From: David Boverman <David.Boverman@rfs.nsw.gov.au>
Sent: Tuesday, 11 June 2019 9:47 AM
To: Rose-Anne Hawkeswood
Subject: Narrabri Gas Project - Supplementary RTS

Thank you for sending the Supplementary RTS for this project to us for review and comment.

**Figure 1: Diagrammatic view of the dimensions of the well pads**

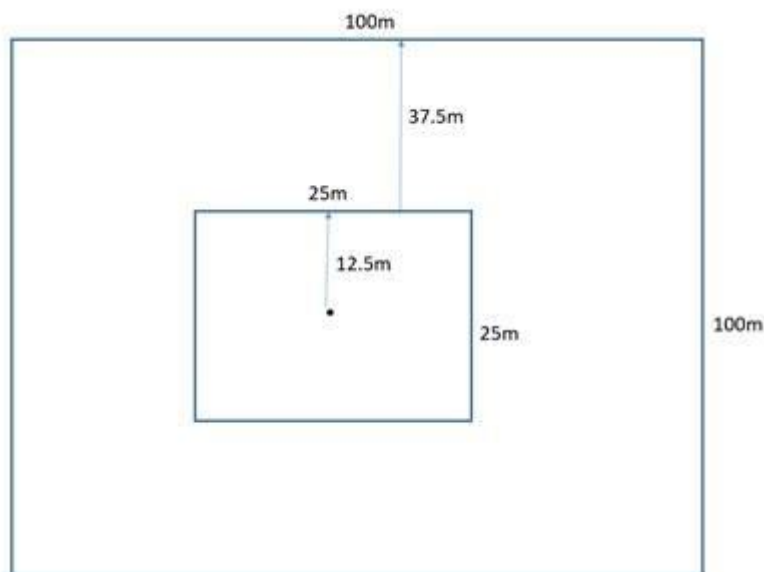
- details on flame length and radiant heat modelling for each vegetation community the well heads are located within;
- advice from a practicing engineer as to the heat exposure to adjacent hazards, based on the well head design & materials (including engineering sign off as being safe from the impact from bush fire);
